## Review of Dendrobium Mine Extension Project SSI-33143123 EIS

Peter Dupen

Engaged by Environmental Defenders Office (EDO)  
on behalf of Protect Our Water Catchment, June 2022

<b>Client</b>	Engaged by Environmental Defenders Office (EDO) on behalf of Protect Our Water Catchment
<b>Prepared in accordance with (proposal &amp; PO)</b>	Expert Brief from EDO dated 01/06/2022
<b>Prepared by</b>	Peter Dupen, H2onestly
<b>Version &amp; Date</b>	H2o010_R01 – 13 June 2022
<b>Previous versions, key information changes</b>	None

STREAMS & SWAMPS

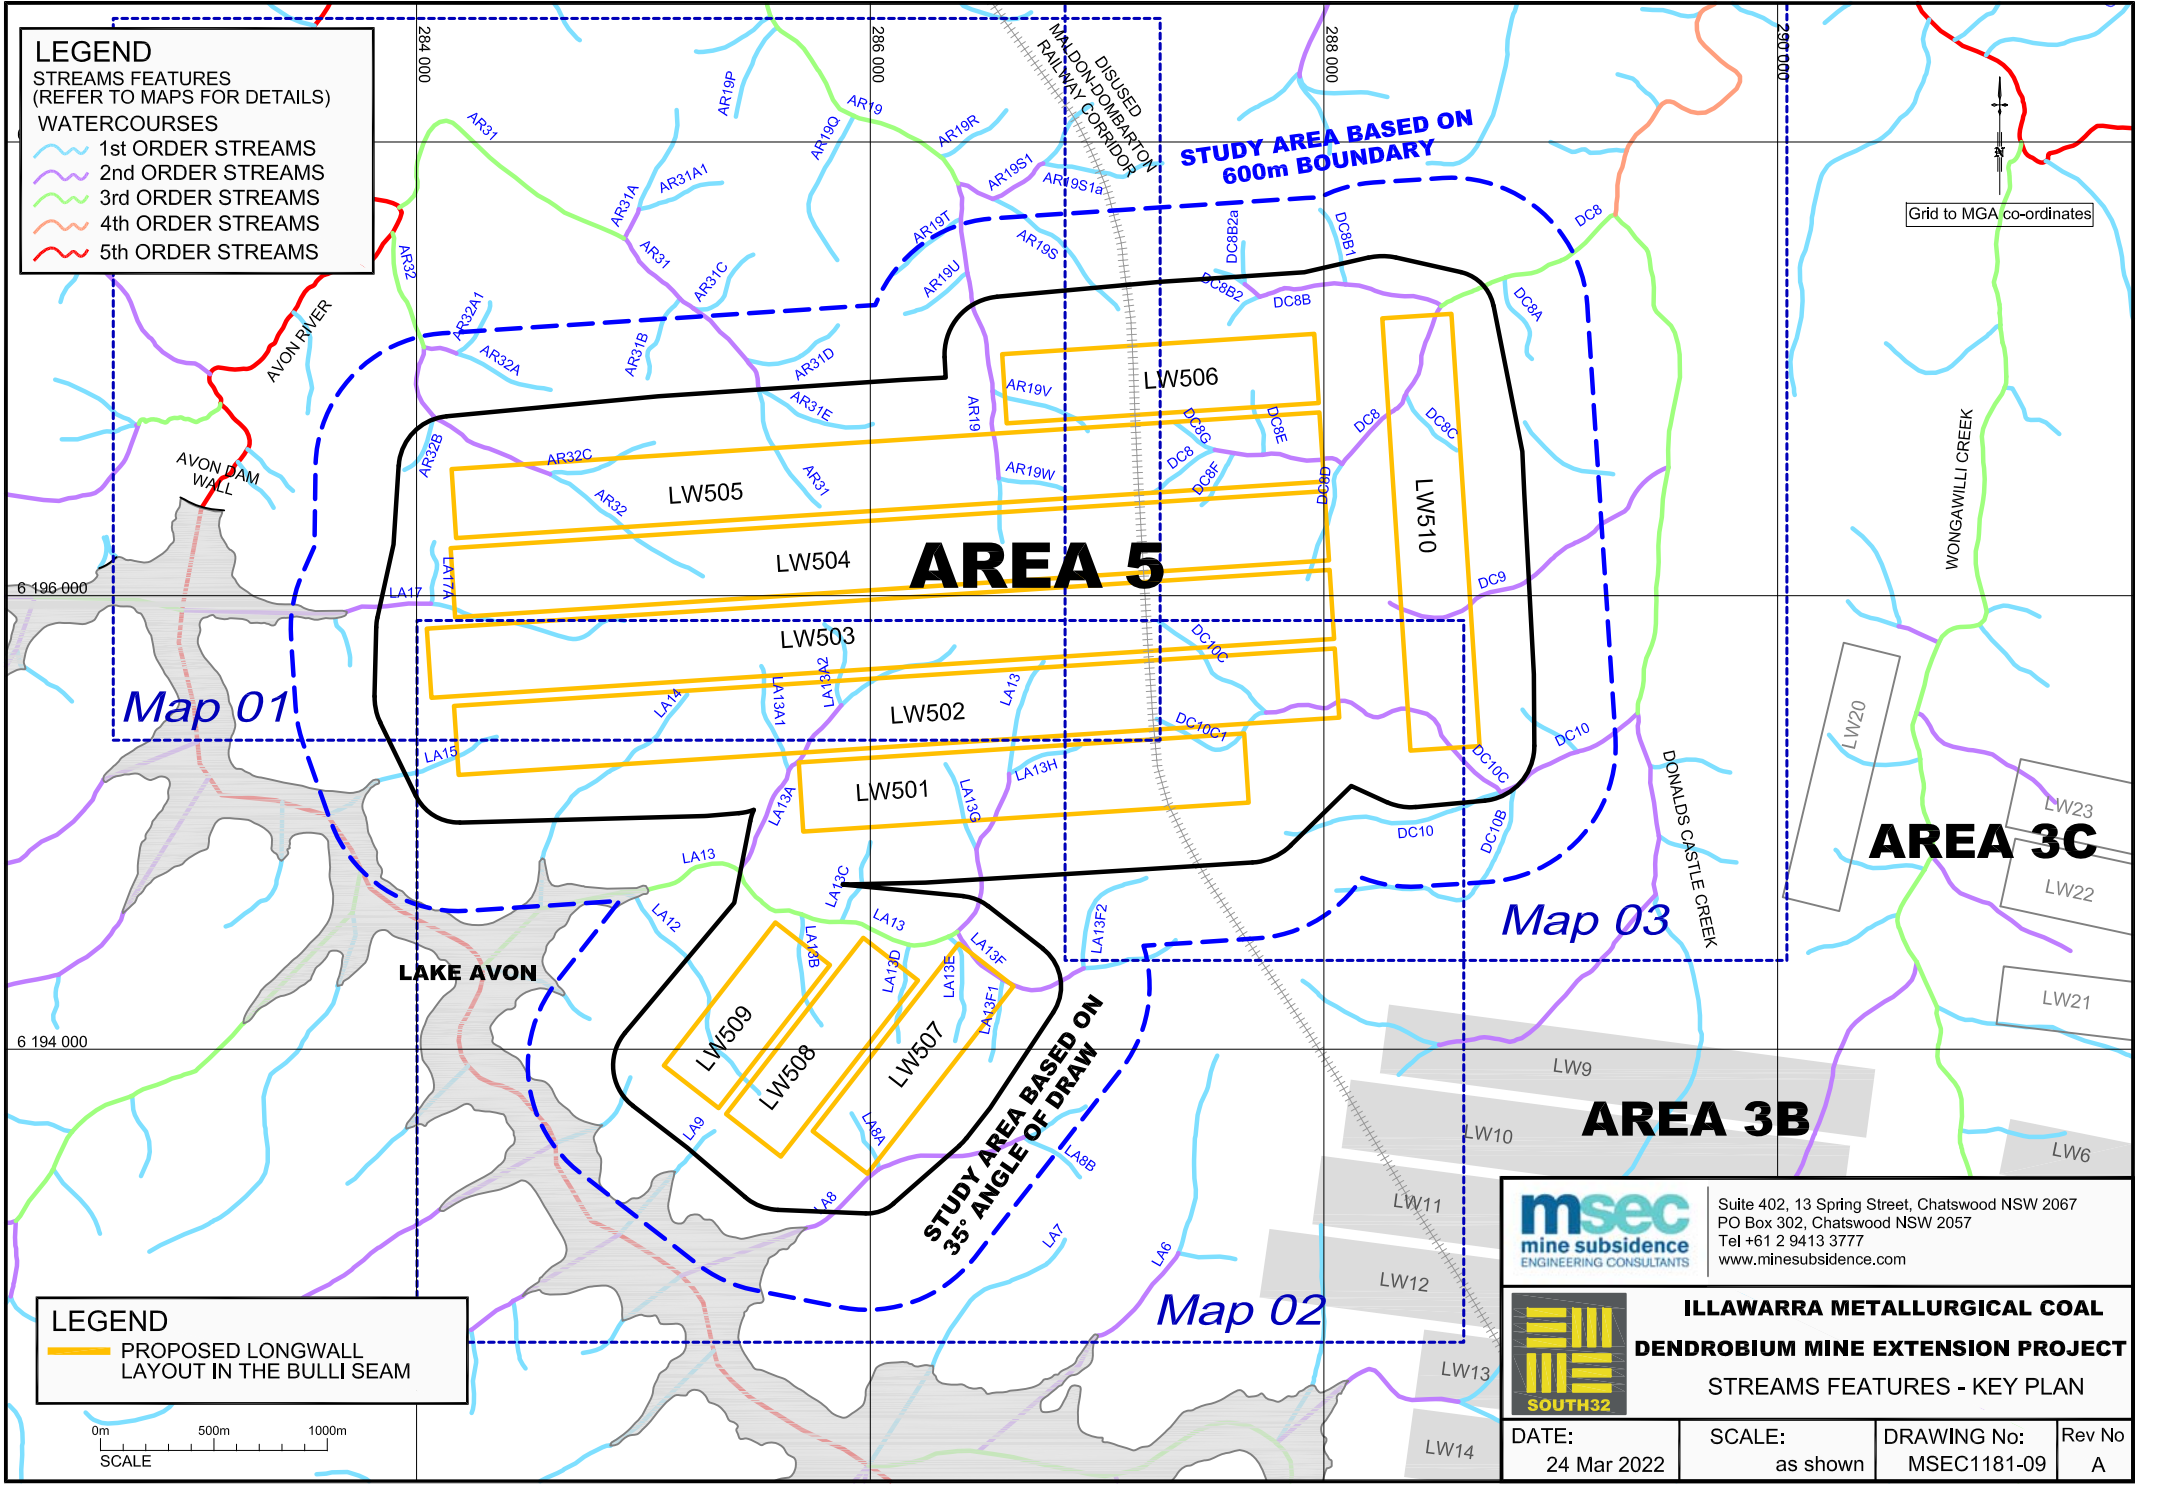
Analyses performed by Dendrobium’s surface water consultants (HEC, 2022) suggest that these stream lengths will be affected by subsidence, and most of the streams and catchments overlying the Area 5 longwalls will become cracked and dry as have the Areas 1, 2 and 3 longwalls to date.

As well as the impacts of the baseflow reductions, MSEC (2022) predicts that fracturing of bedrock would occur along the sections of the first and second order streams that are located directly above and adjacent to the proposed longwalls. They therefore acknowledge the potential for partial or complete loss of pool holding capacity to occur at these locations, and lesser impacts in the zone up to approximately 400 m from the proposed longwalls.

MSEC (2022) also predicts that approximately 15% of the stream controlling features (i.e. rockbars, steps and other controlling features) located within 400 m of the proposed longwalls could experience Type 3 impacts, described as fracturing in a rockbar or upstream pool resulting in reduction in standing water level. These effects are likely to occur in five of the stream rockbars, and these streams may thus also incur partial or complete loss of pool holding capacity.

There are 22 upland swamps located within 600 m of the Area 5 longwalls, as shown in Figure 8 of HEC (2022). Of the 22 upland swamps within the Study Area, 16 are within 60 m of the proposed longwalls and the other six are located outside the immediate extents of the proposed longwalls.
